Application No.: BS-18-00001

BOWERS FIELD AIRPORT BINDING SITE PLAN ~ NARRATIVE PROJECT DESCRIPTION ~

BOWERS FIELD AIRPORT BINDING SITE PLAN

TO: Jeremy Johnston, Planner - Kittitas County CDS
FROM: Justin Turnbull, County Surveyor *ST*
DATE: January 11, 2019
SUBJECT: Bowers Field Binding Site Plan Application

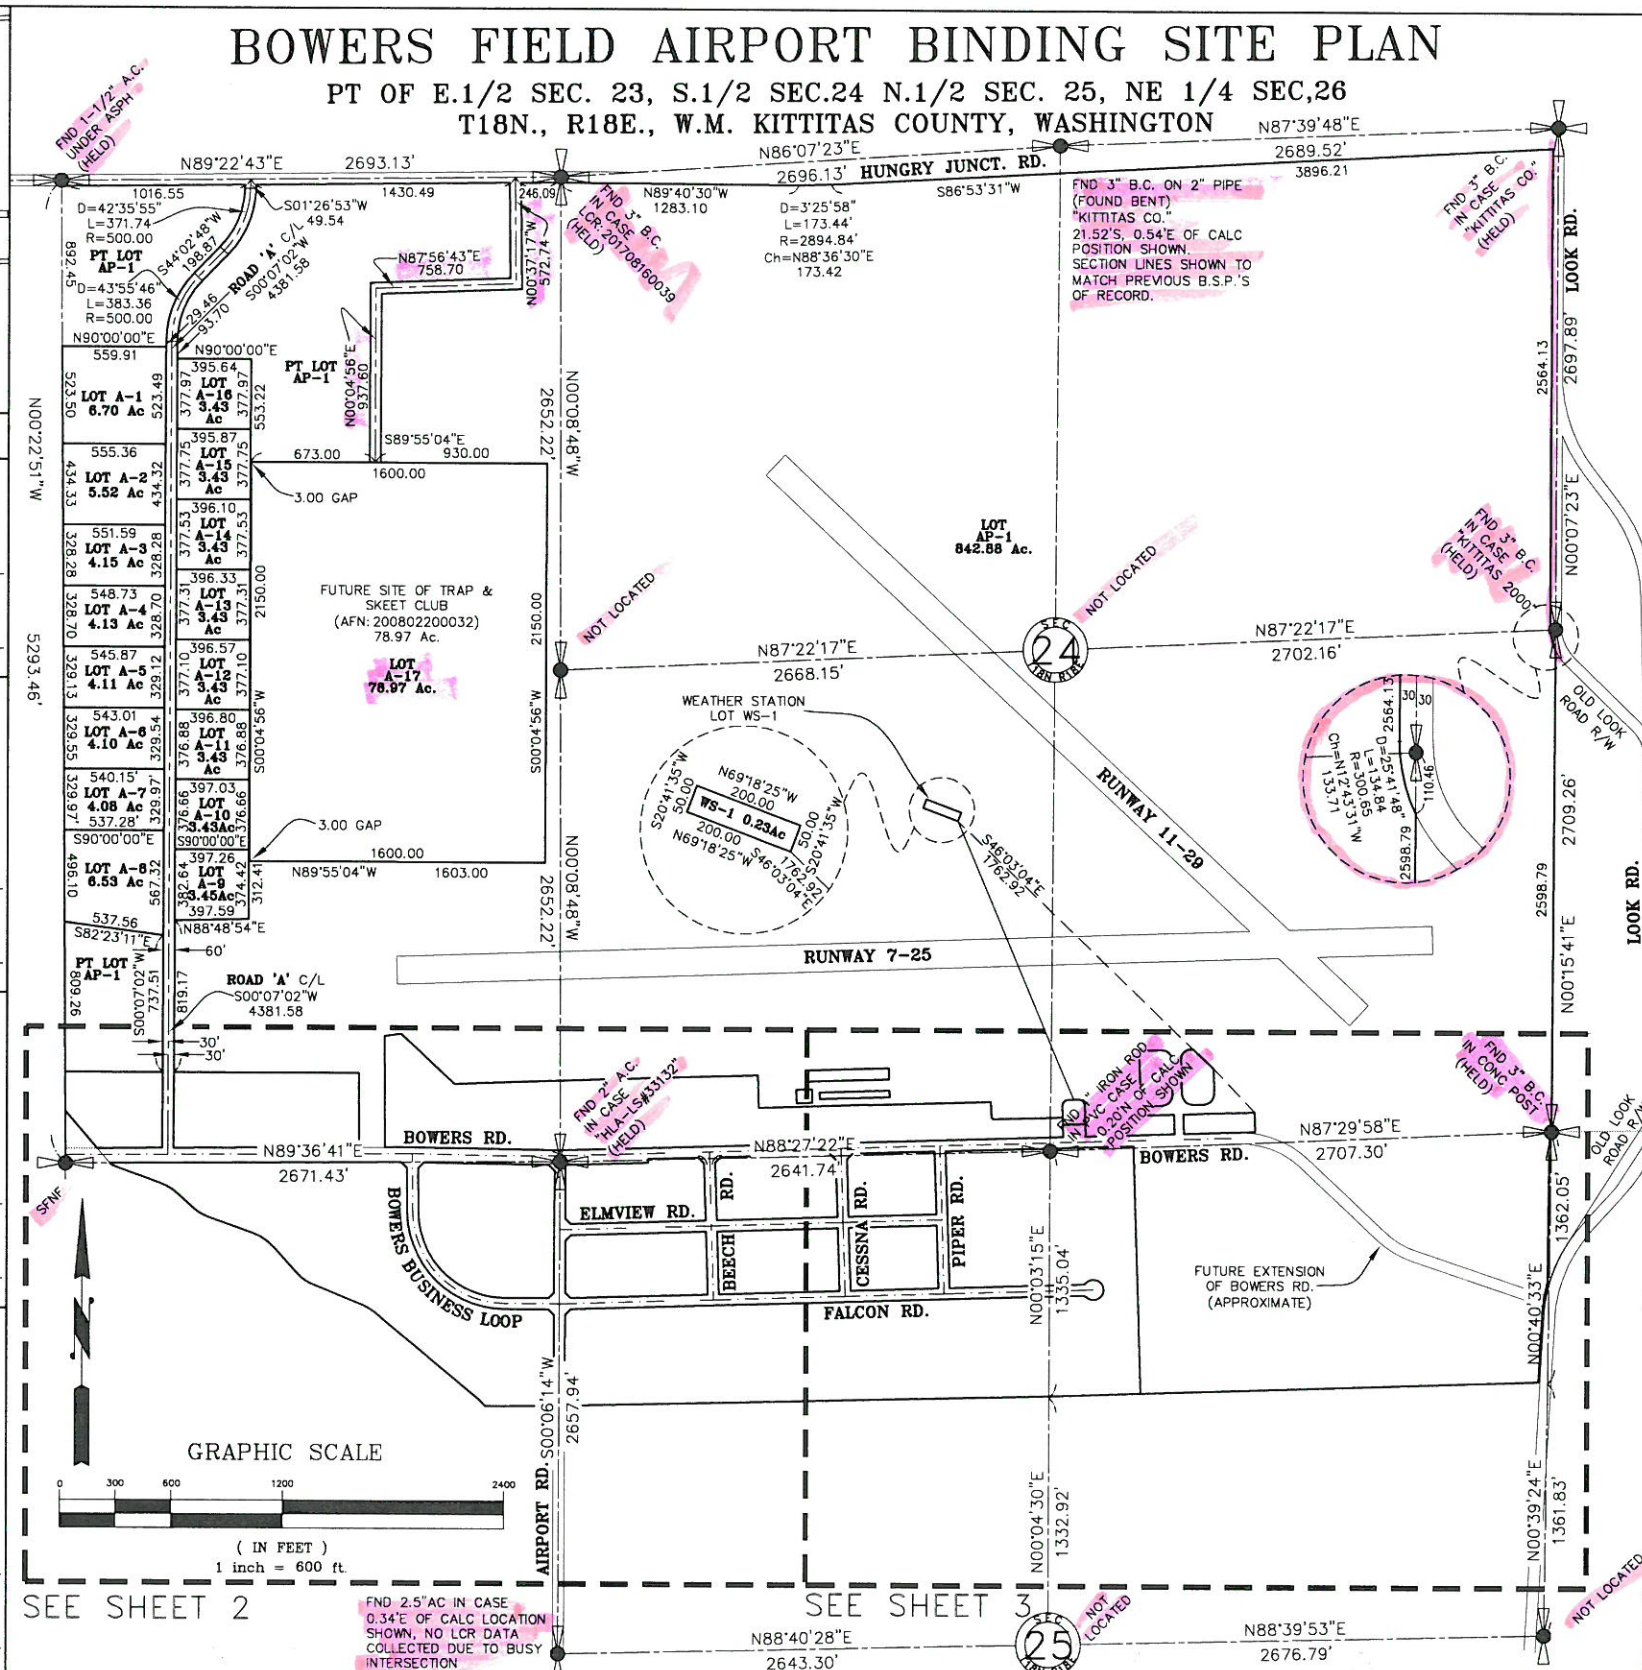
Exterior Airport Boundary

The 2010 BSP never actually surveyed the boundaries, nor the section lines, nor did they properly locate the Road Right of ways. Also the large parcel containing the runway was never assigned a Lot Number. These are reflected in the new site plan.

LOT AREAS		LINE TABLE	
LOT	AREA	LINE BEARING	DISTANCE
H-19	0.14 Ac	L1 N88°12'30"E	65.00
		L2 N01°47'30"W	110.80
		L4 N01°47'30"W	60.00
		L5 N01°47'30"W	36.00

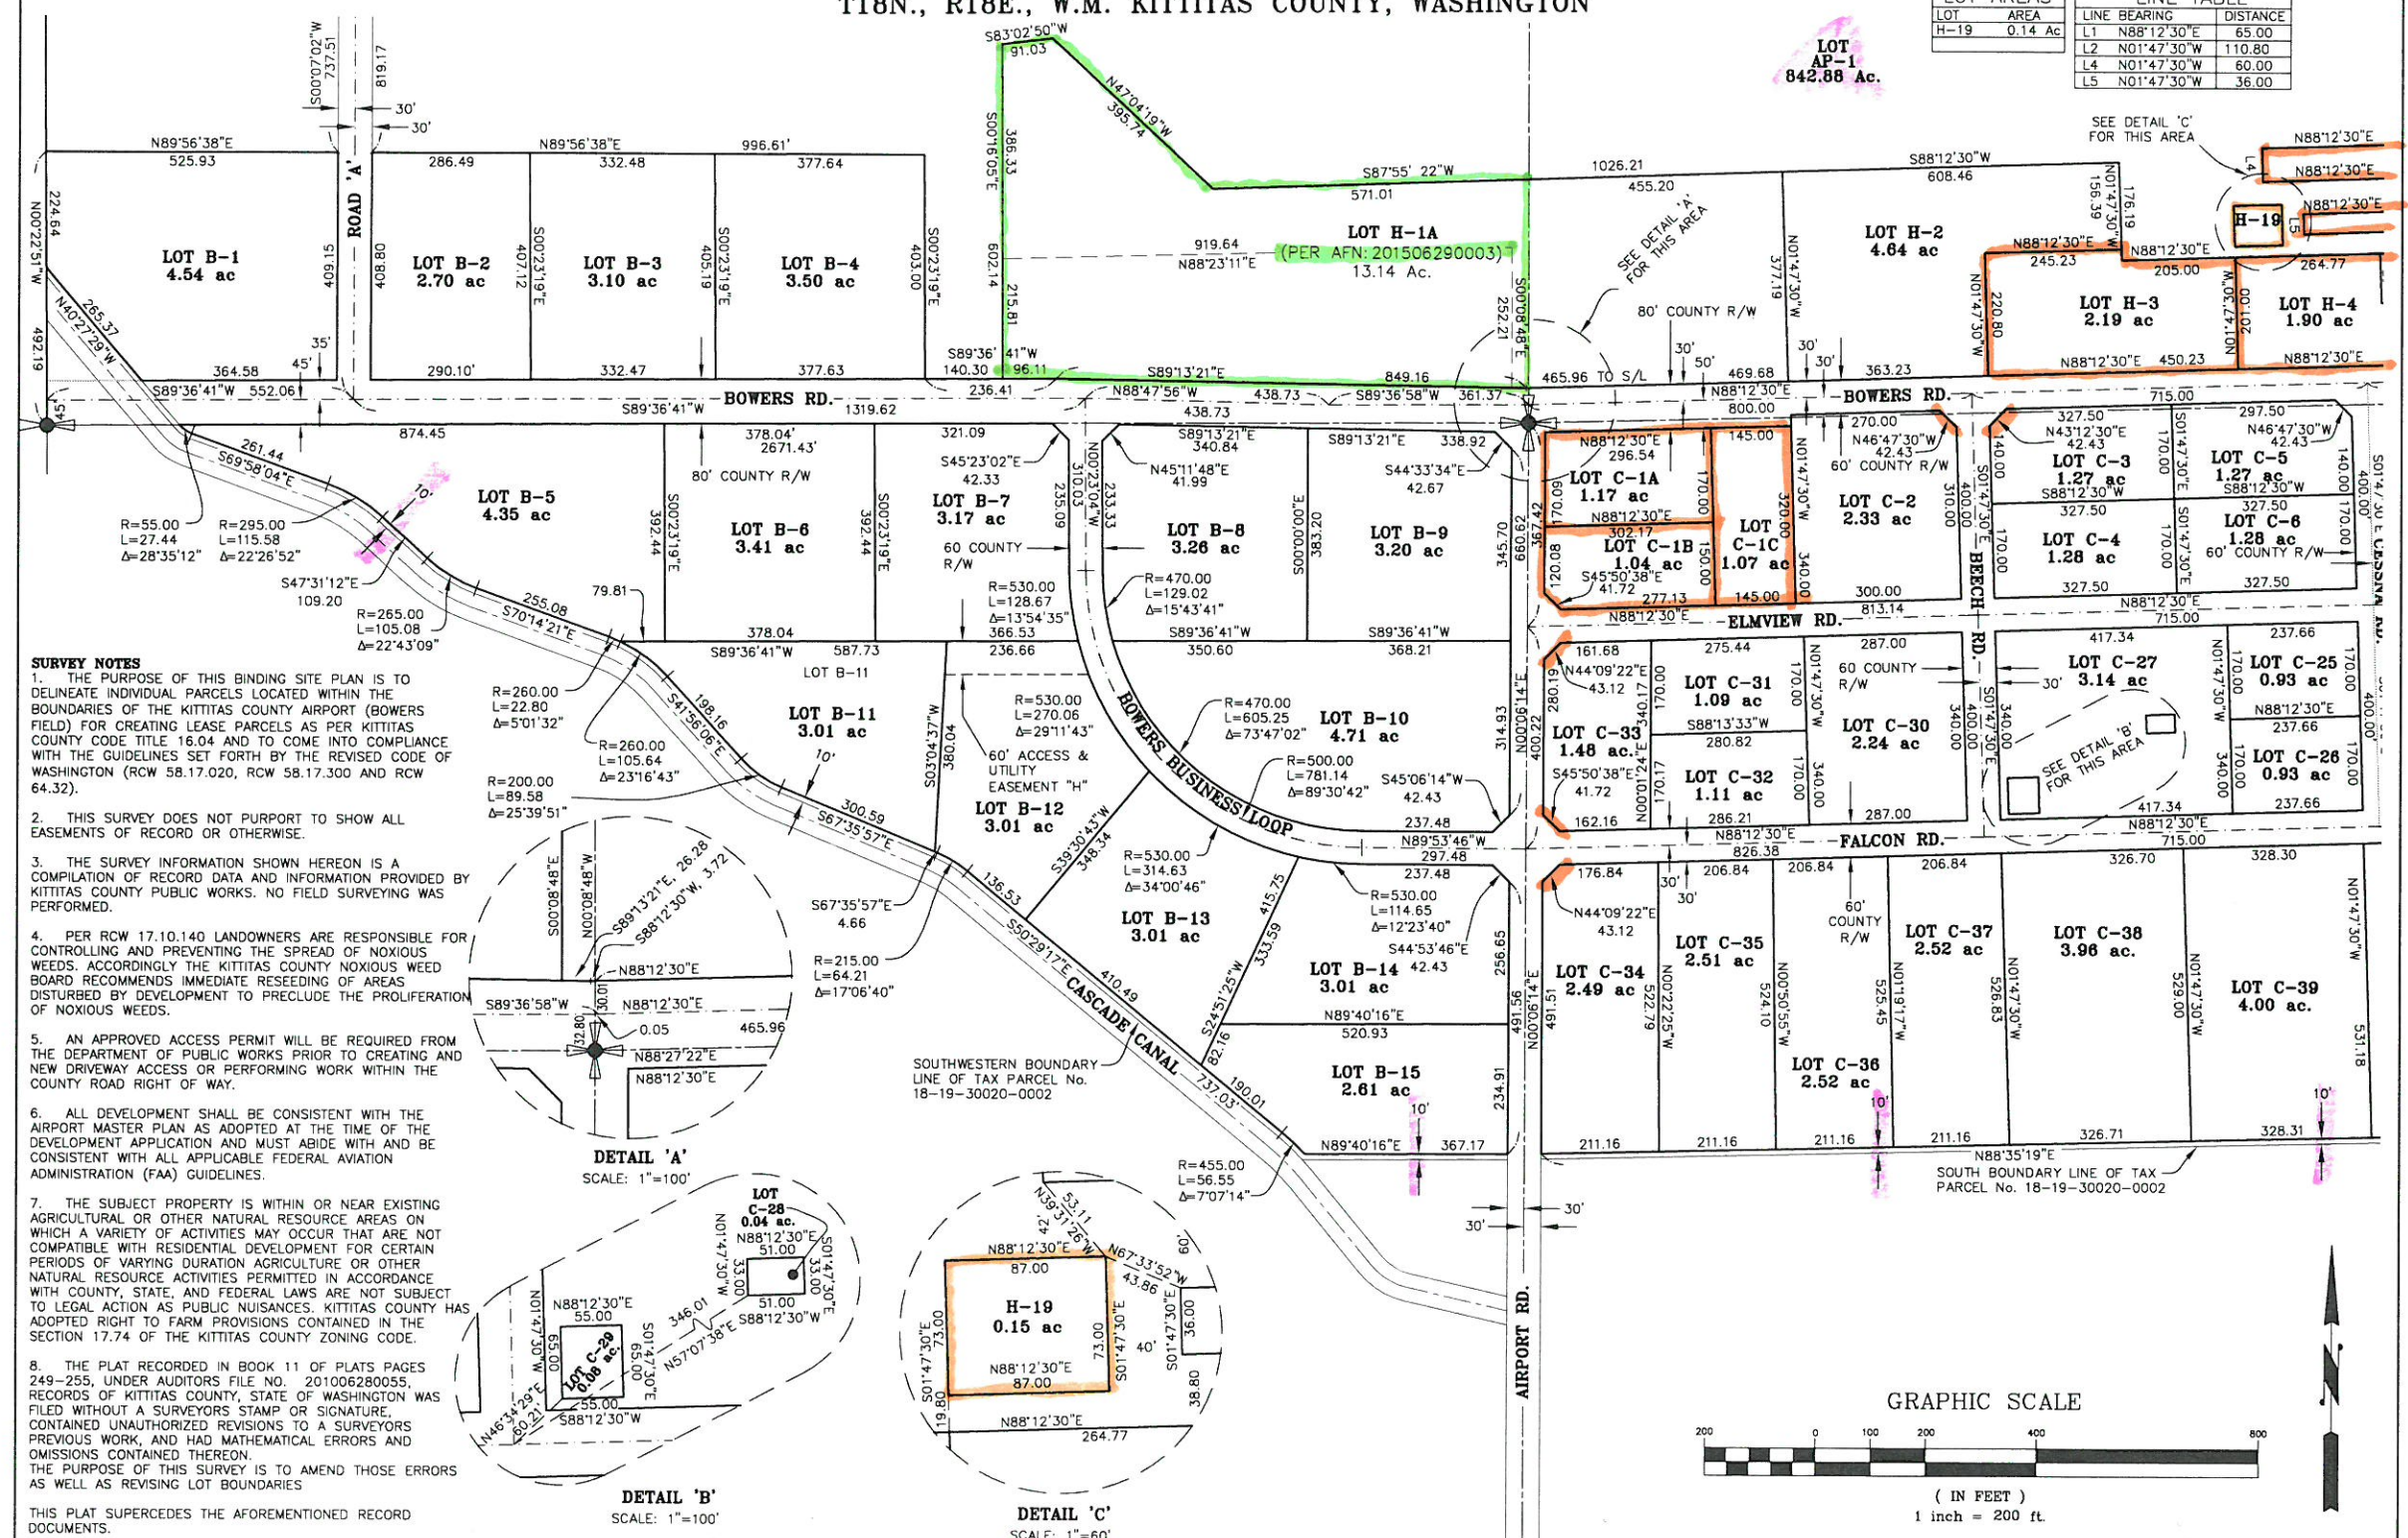
Lots C-1A, C-1B, C-1C

Created new lots at the request of the lease holder of Lot C-1A.

Lots C-33, C-34, C-2, C-3, C-5, C-7

Changed Lot Lines to reflect curb radiuses falling outside existing right of way

Lots H-19, H-20, H-20A

Minor corrections to create a parallel parcel, and /or fit the existing building entirely within the Lot.

Lots H14, H-15, H-16, H-22, H-23, H24

Radiused corners to reflect existing asphalt of Airport Taxiway, Changed layout to reflect future use of airport leases to support larger aircraft.

Lots H-5 to H-13

Revised Lot layout to allow for larger aircraft.

Lots H3, H4

Revised Lots to allow for predicted business or agency use.
